## **APPENDIX:**

### **Layout, Scale & Massing – see markup of proposed site plan below intended to engage with the Applicant over a layout and massing that might integrate better with the existing townscape:**

Client: Tri7  
 Project: Calthorpe Street, Banbury  
 Drawing Title: Ground Floor Site Plan  
 Drawing Status: **PLANNING**

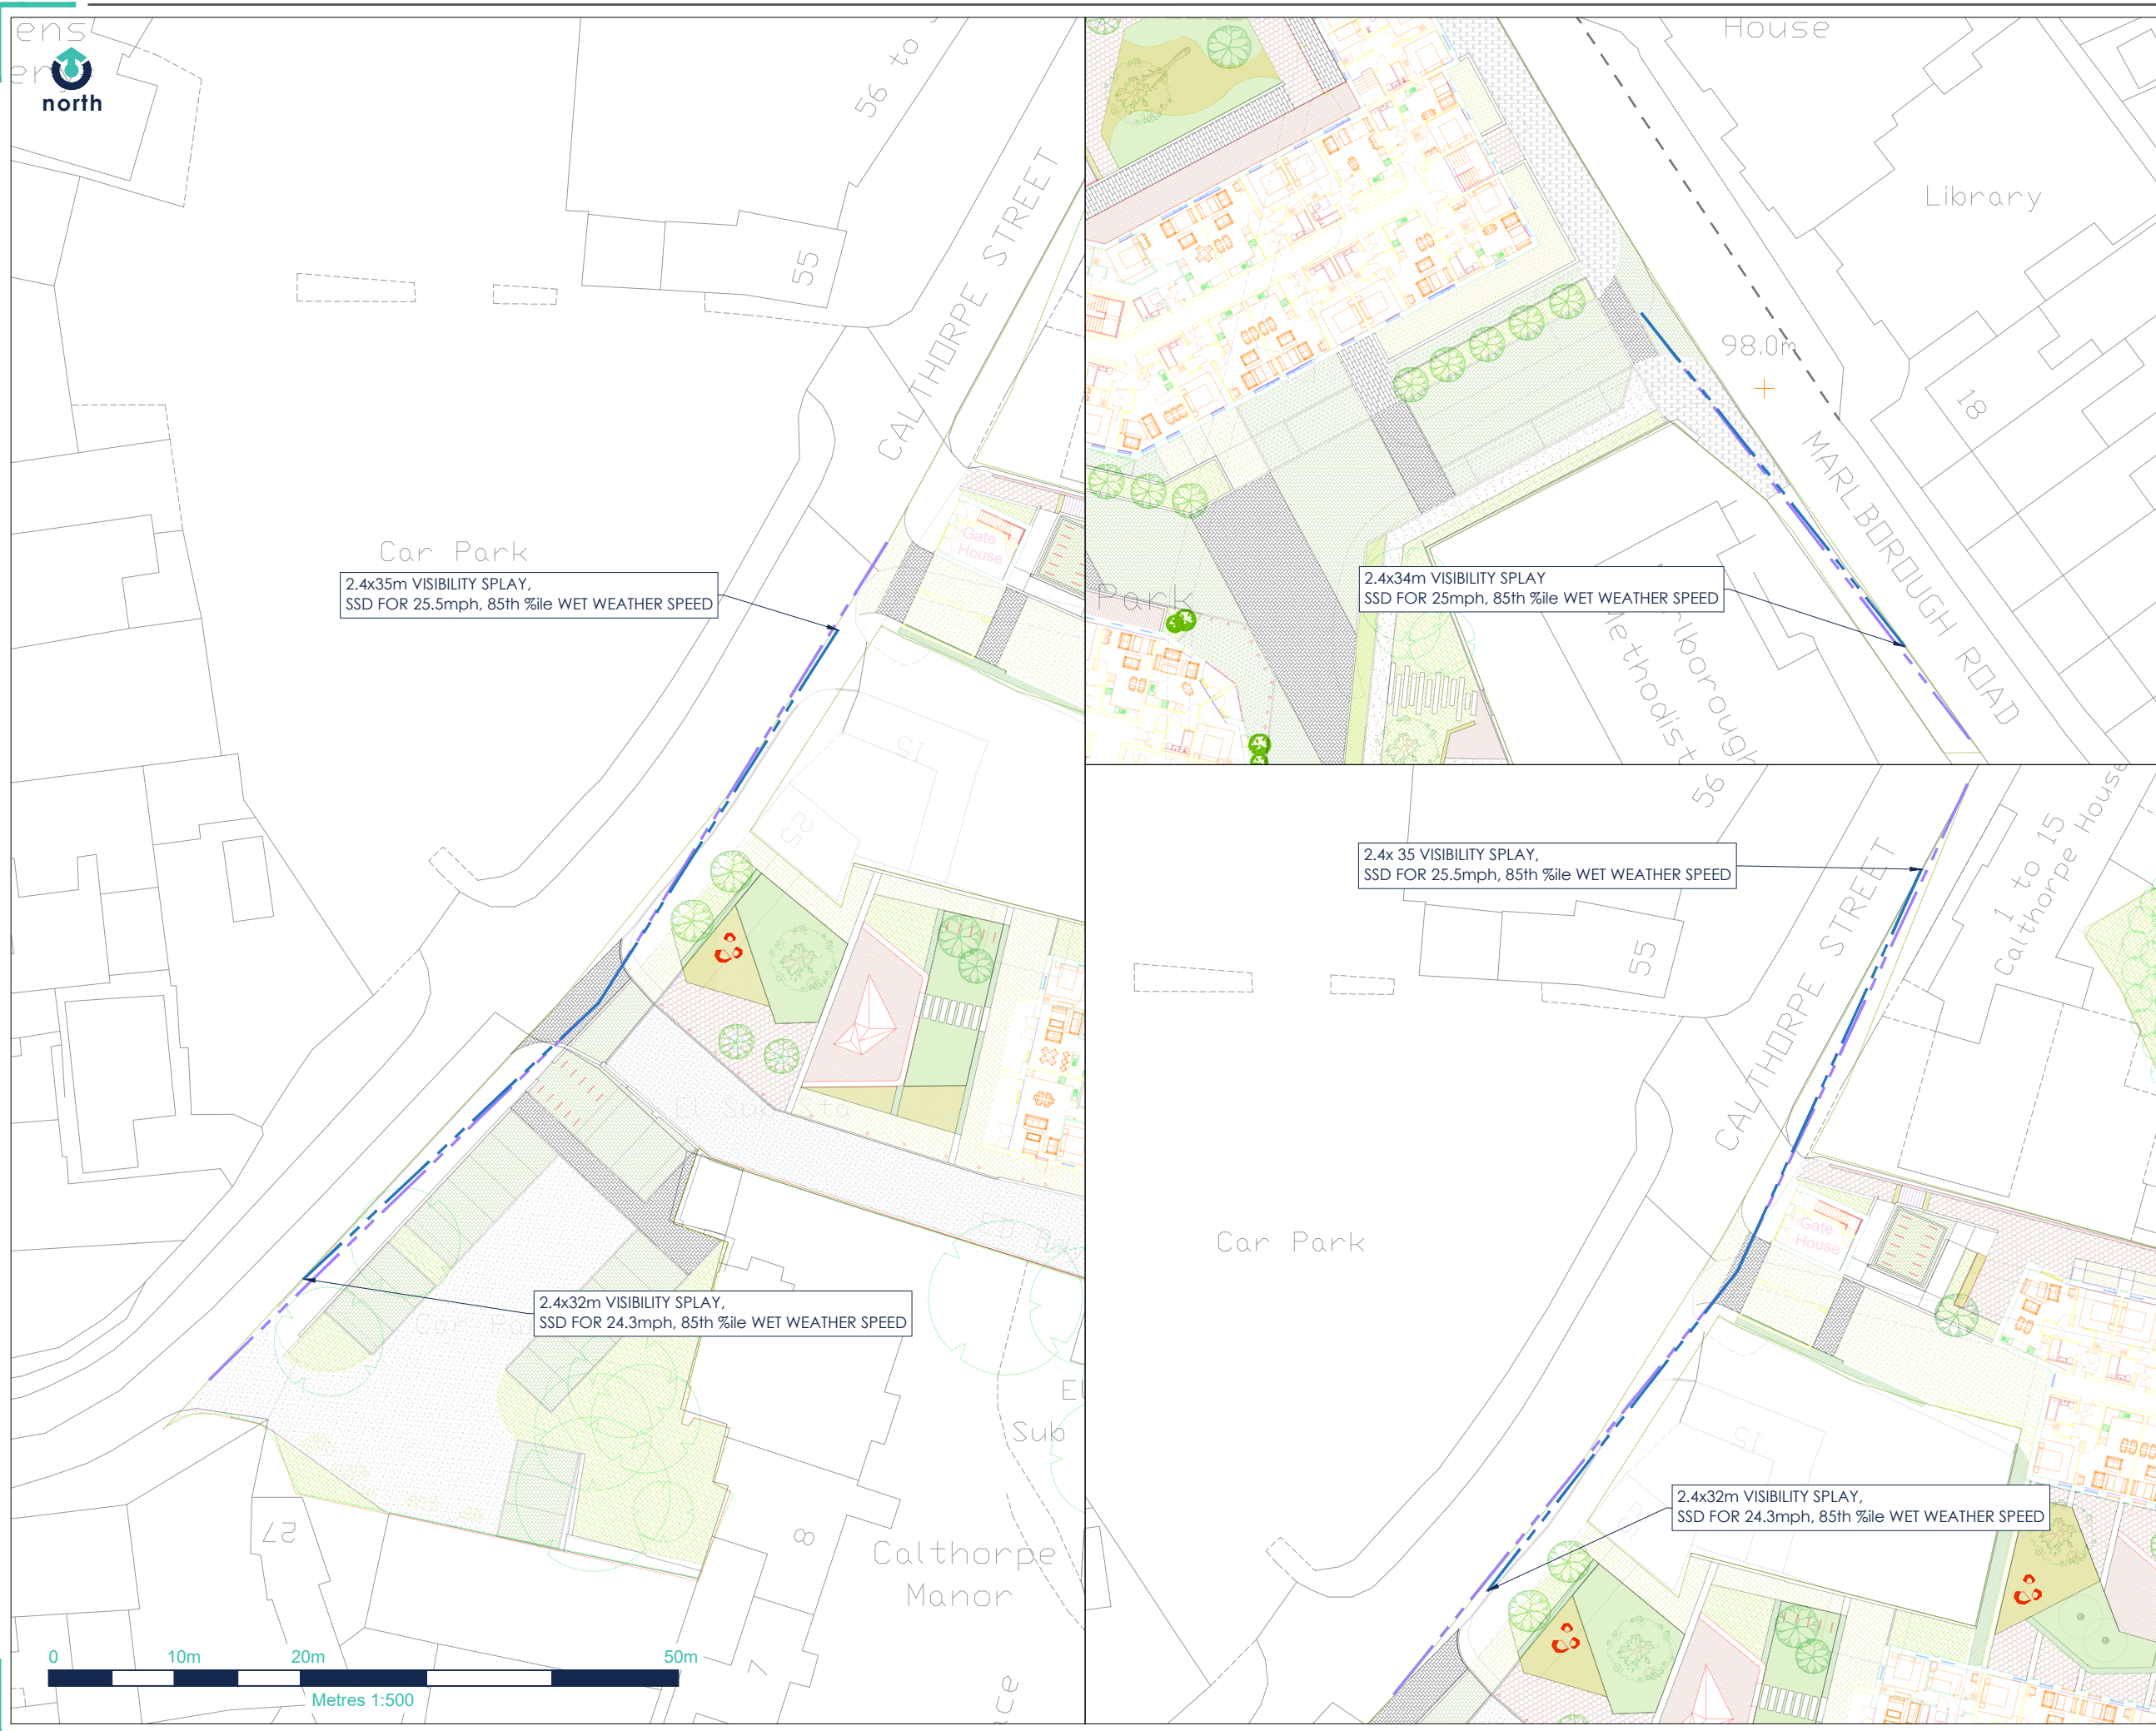
The central band of the site is where we could see new development of comparable height to Calthorpe House (relative to the eaves of Calthorpe House) and the Library and the old technical college, so long as the library remains the dominant building in terms of hierarchy. Please note that on Calthorpe Street, the massing and height of Calthorpe House appears less due to the clerestory floor above the masonry. The blocks proposed are monolithic with little interest in the skyline or Elevation when compared to the Banbury Conservation Area.

The setting of Calthorpe Manor has been heavily compromised. There is a real opportunity for heritage benefit by greening the area to the west and north of Calthorpe Manor. It would be good to see the mature trees retained, supplemented by trees appropriate for a car park if the small pocket surface car park remains west of the manor. To the north, there would be potential for an avenue of trees to line the lane to the proposed townhouses (see later comments), with further greening up to the former gatehouses (NDHAs)

The introduction of a terrace of 2 – 2.5 storey townhouses would be welcomed although the height looks to be quite tall given the land levels, the plan depth, in the setting of the Grade II\* manor nearby. The gables to the front are not thought to be a positive addition as shown. The townhouse concept could extend into the site and create a buffer between the development in zone X, and the existing terraces to the south-east of the site. This could be a mix of traditional terraced proportion but could also add in the gabled house types seen at preapp in a nod to the former saw-tooth factory roof seen on old aerial photos.

The new 'gatehouse' leads to confusion with the historic gatehouse. The principle of closing the gap is welcomed and should respect the height of the adjacent NDHA.

The terrace running south from the High Street towards Calthorpe House should start low to respect the retained 2-storey building on the High Street, and gradually step up the hill to a similar height as Calthorpe House. The including of street trees would help to soften the views. The roof line could be traditional pitched roofs at this point, with ridges parallel to the street. Frontages should respect terrace proportions.

The terrace running south from the High Street towards the Methodist Church should start low to respect the retained vernacular 3-storey building on the High Street, and gradually step up the hill to a slightly lower height than the Library and former technical college. The including of street trees would help to soften the views. The roof line could be traditional pitched roofs at this point, with ridges parallel to the street. Frontages should respect terrace proportions. The articulation of what is proposed here requires refinement.

'Block F' links between D and E, then this should be driven by the heights to the south of B and E.

This is within Zone X: 'Block E' could have a greater footprint (longer) to compensate for the part reduction in height. The height should respect Calthorpe House and the Methodist Church, excluding the spire.

In turn, H could be a further slightly higher terrace than those indicated at B, possibly 3-3.5 storeys.
